Our Case Number: ABP-309770-21

**An
Bord
Pleanála**

Date: 21 April 2022

Re: Proposed development of up to 15 wind turbines with a tip height of up to 175 metres and laying of approximately 26km of underground electricity cabling to facilitate the connection to the national grid, and all associated site development works
Townlands of Camagh, Carlanstown, Coole, Clonrobert, Clonsura, Doon, Monktown, Mullagh, Newcastle and other townlands, Co. Westmeath

Date: 17/02/2021 Checked By: MG

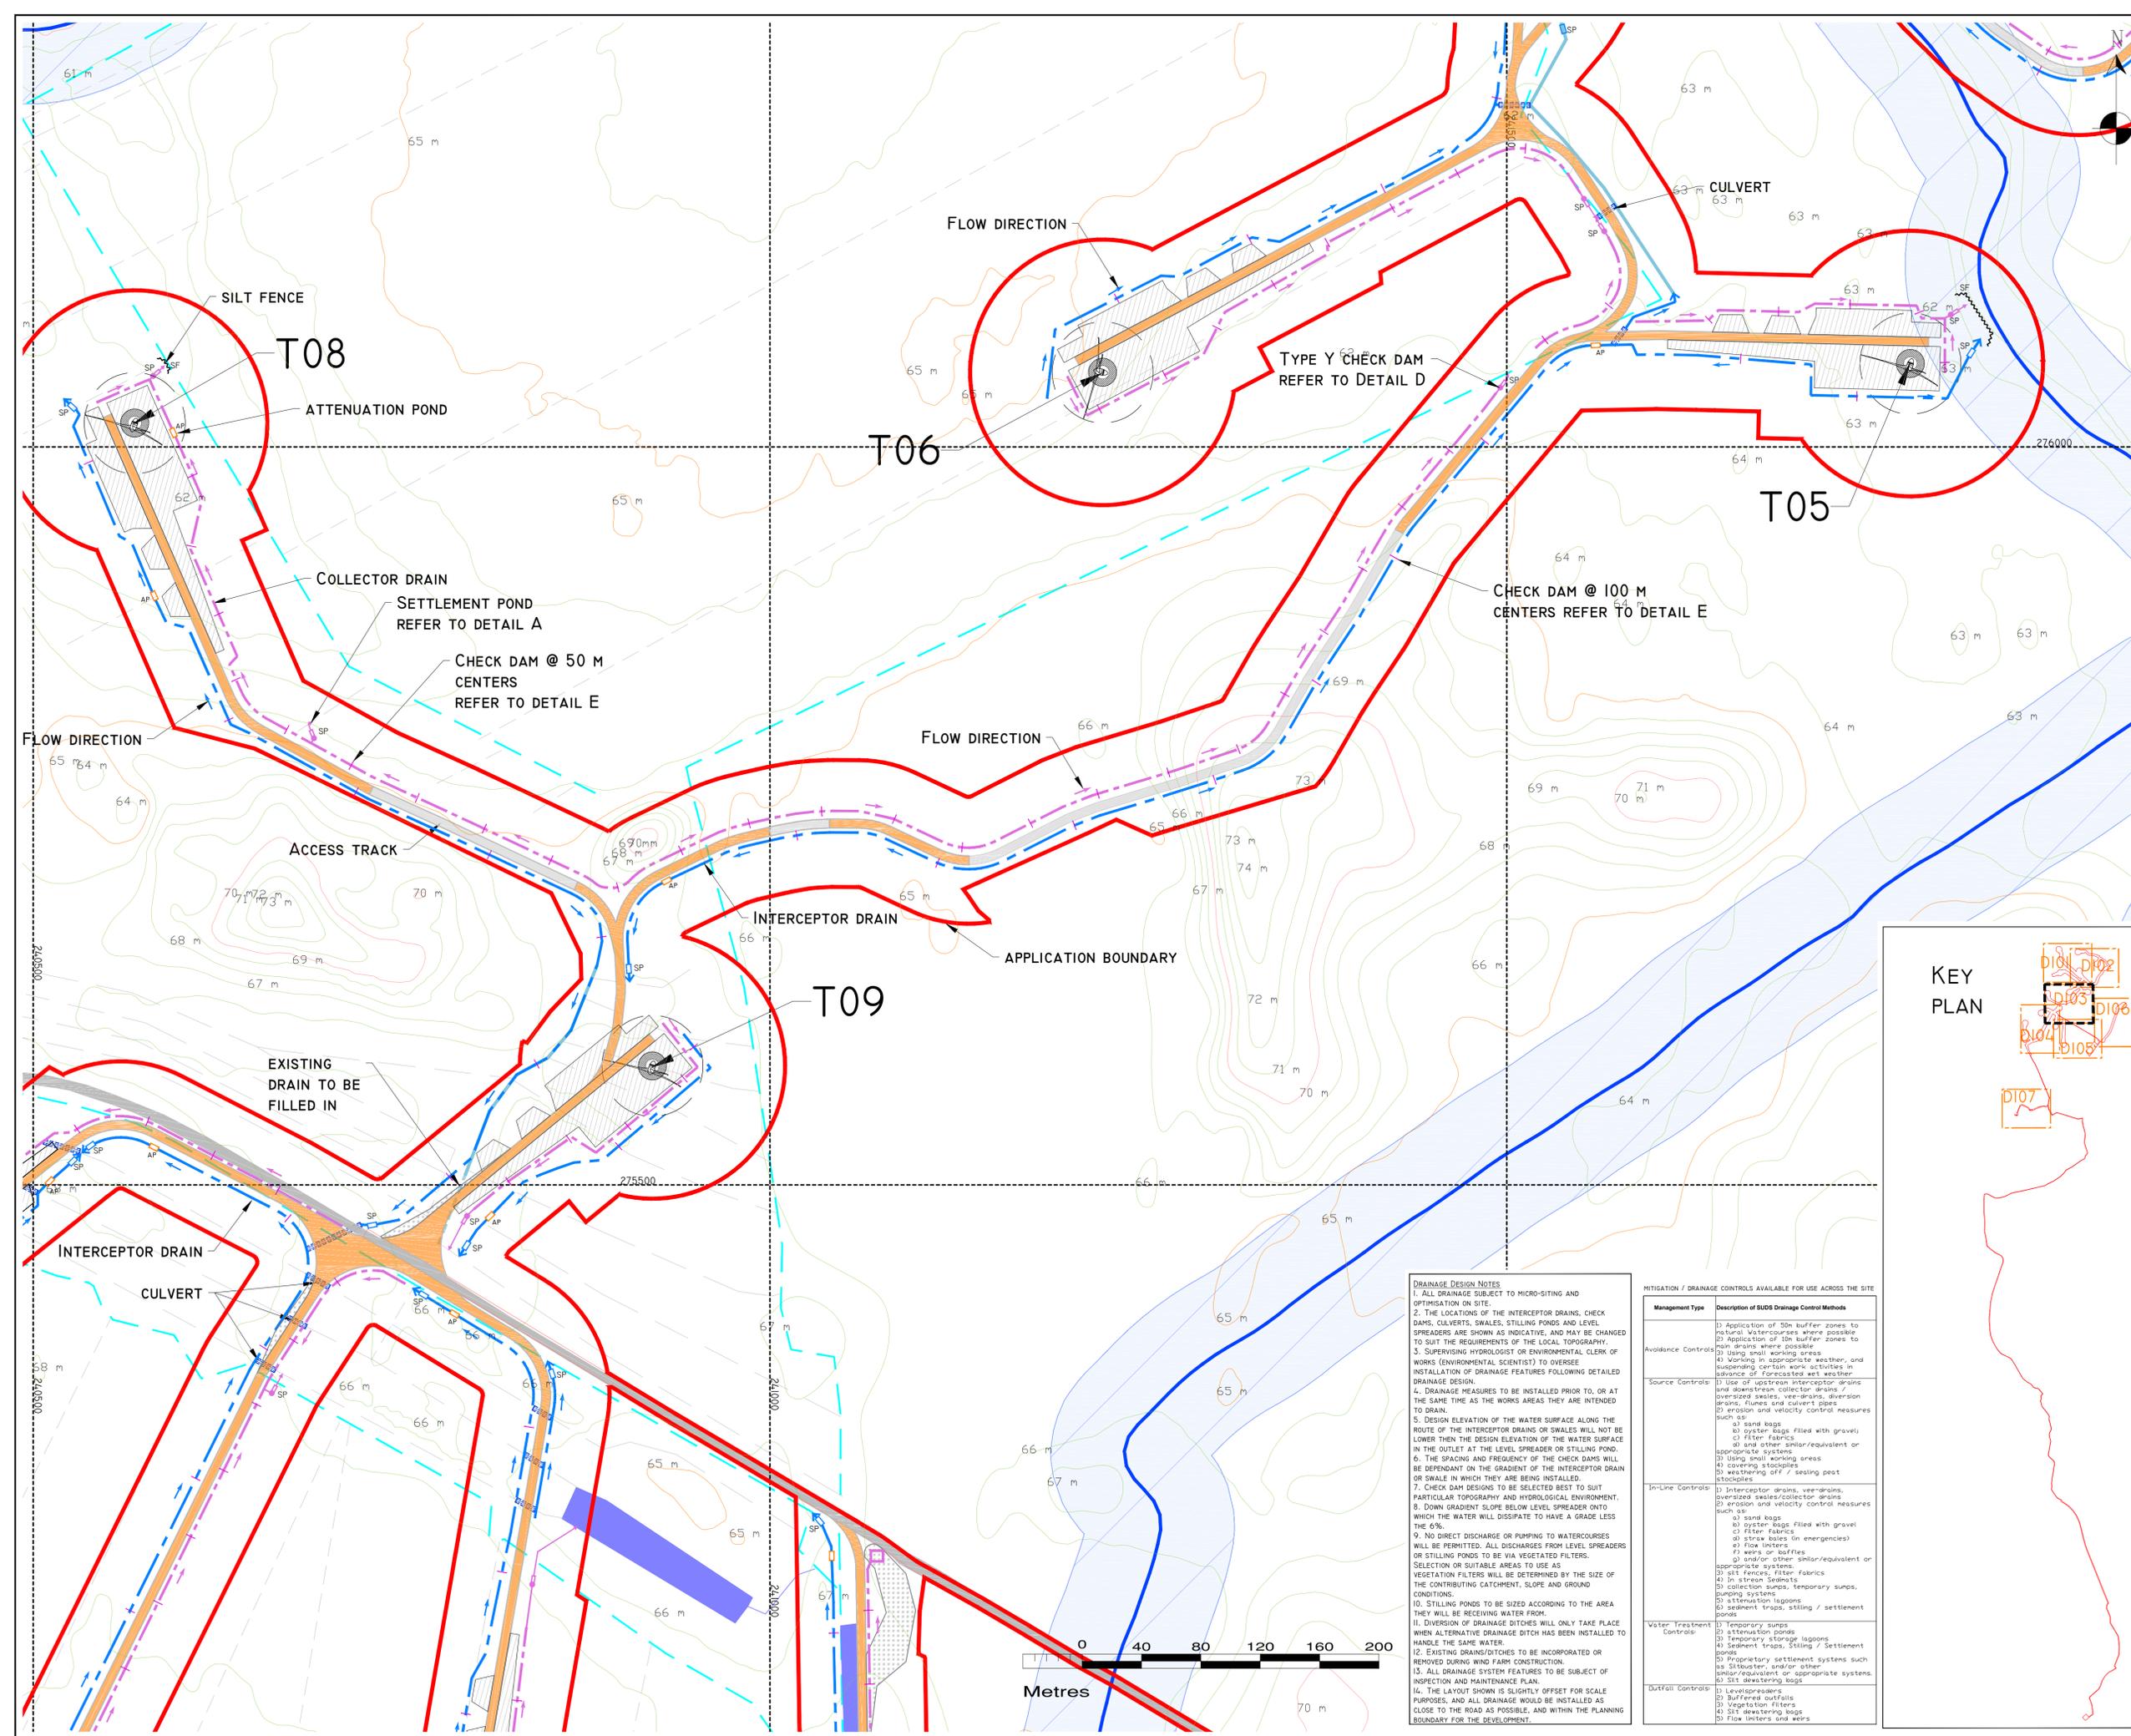
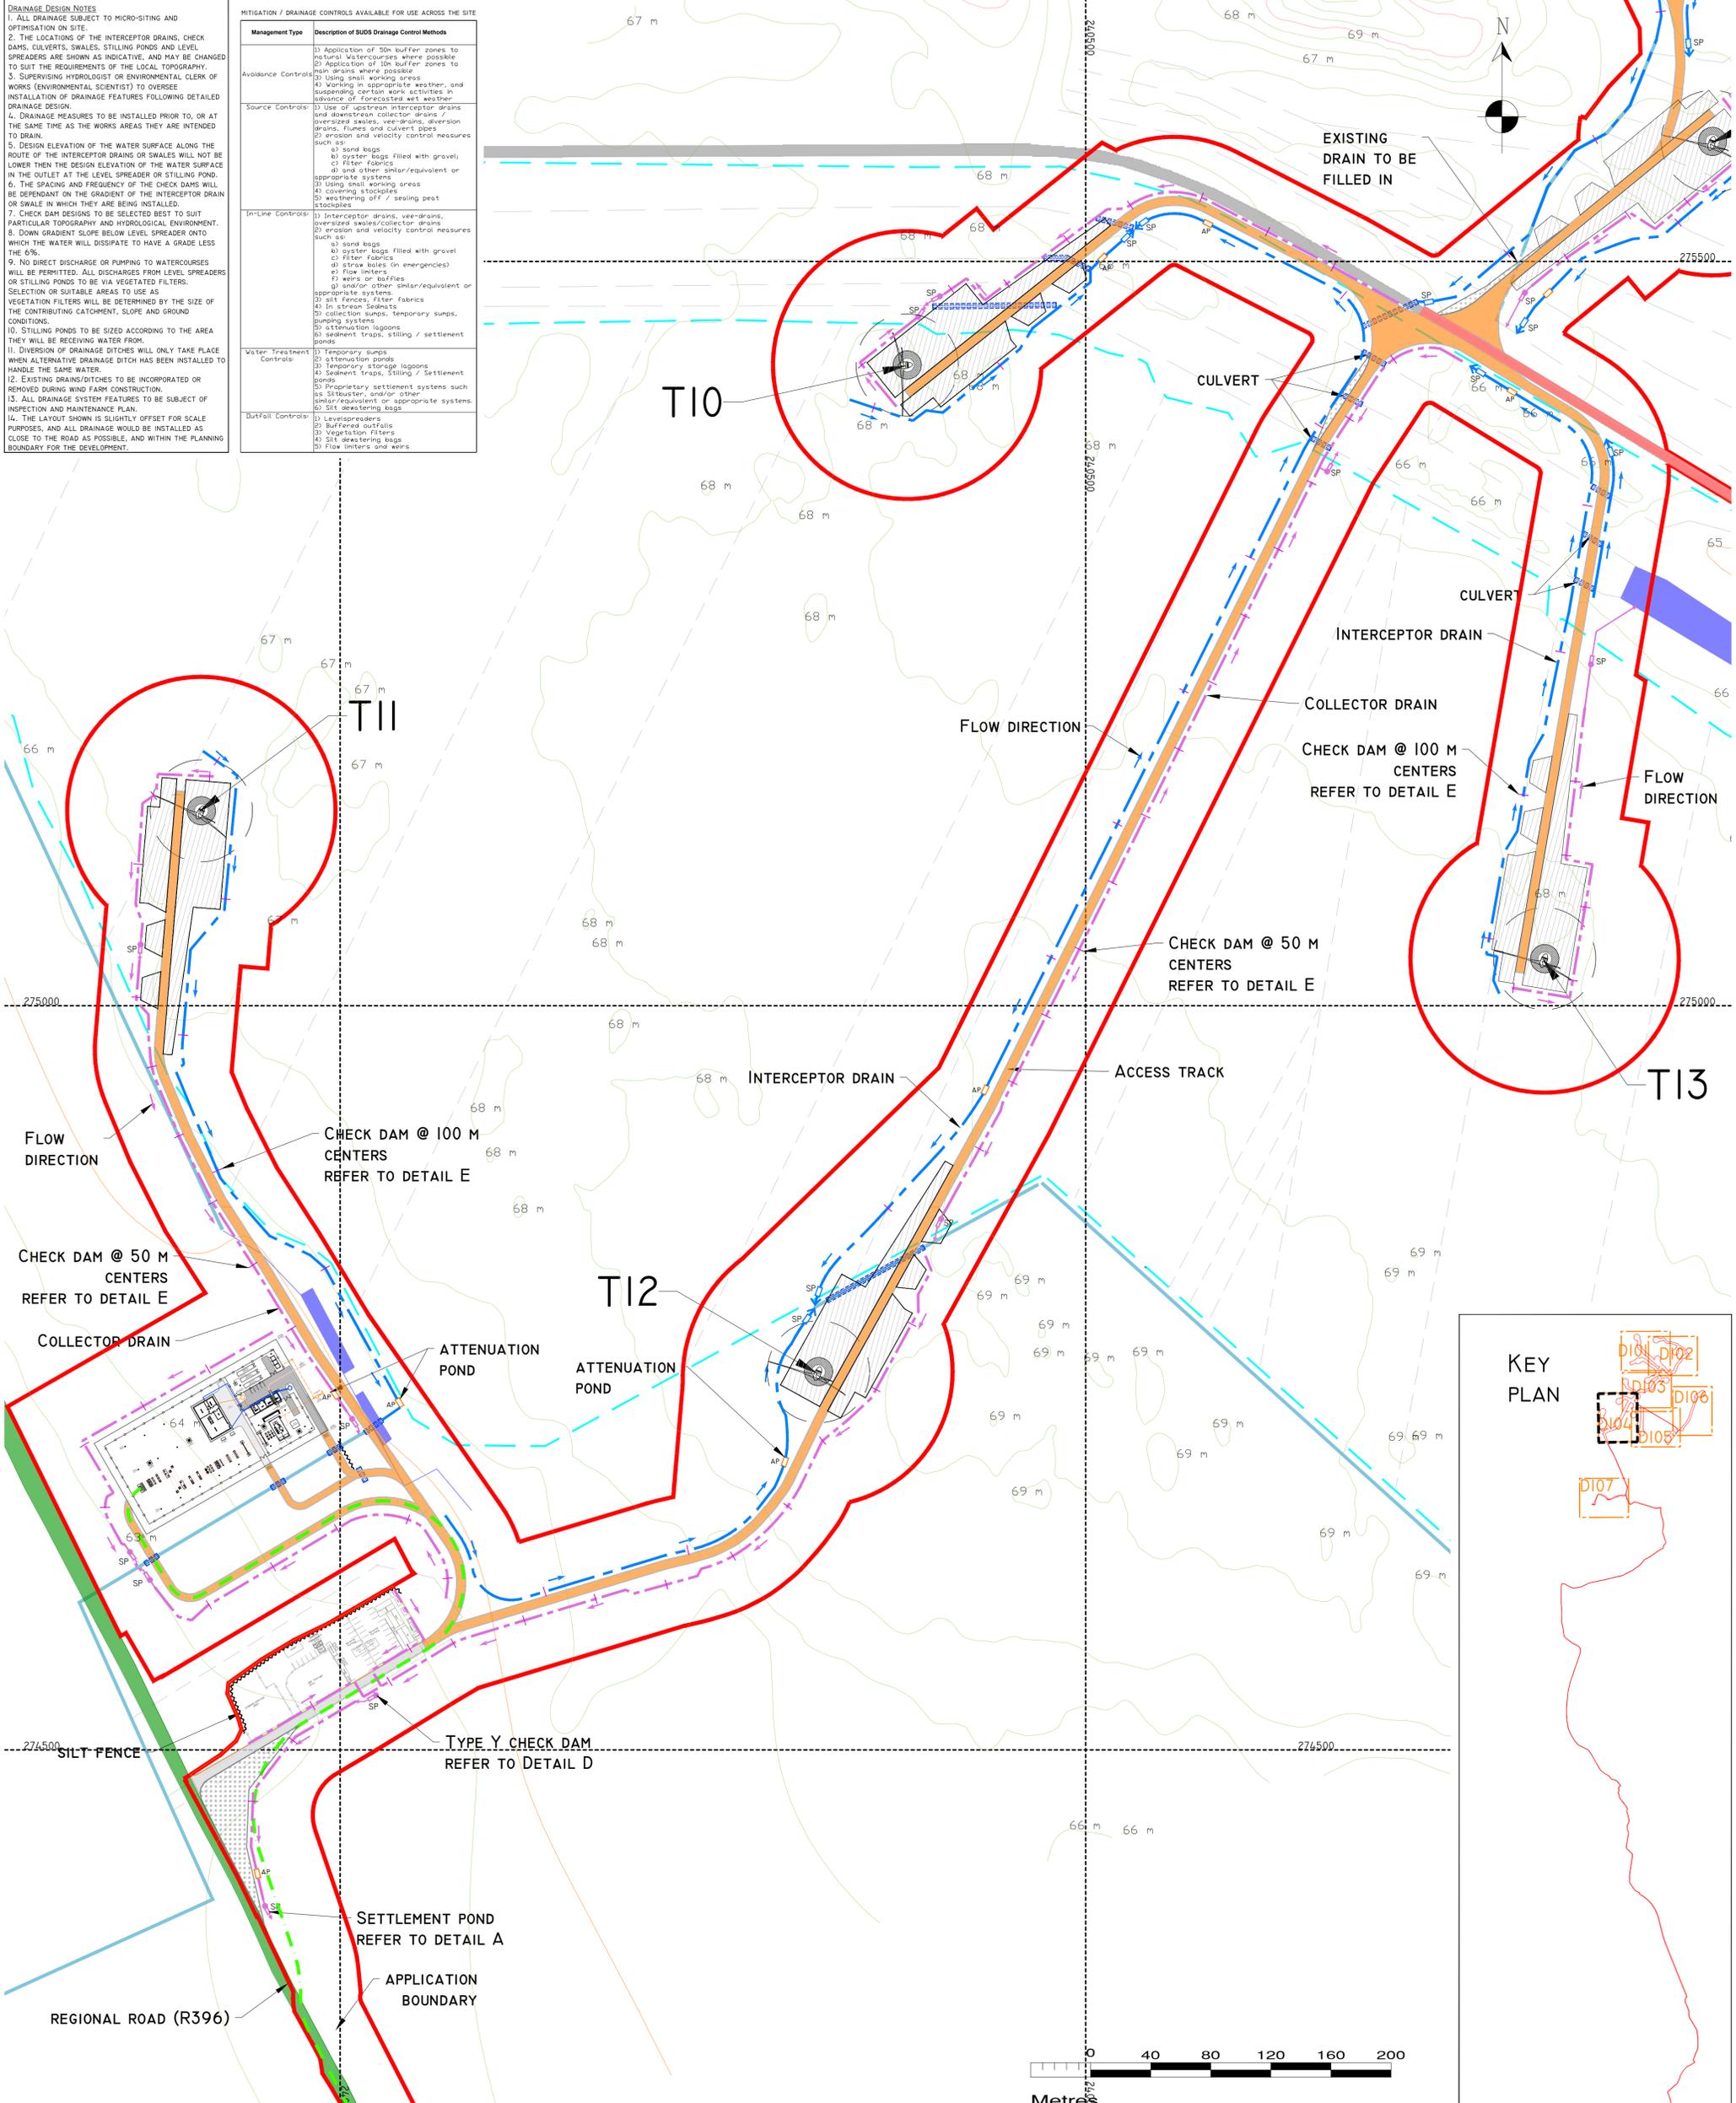
- 4.3. The EIAR is stated to set out the coordination between the peat harvesting activities should they continue and the proposed development in terms of the drainage system. The detailed drawings provided in appendix 9 – 3 of the proposed drainage system are noted. You are requested to demonstrate sufficient control over the existing drainage associated with the peat harvesting activities and to clarify that the proposed drainage plan can be effectively implemented, regardless of whether or not peat harvesting is taking place and the associated drainage system being maintained.

- 4.5. You are requested to clarify the layout and management arrangements for the operational phase drainage structure.
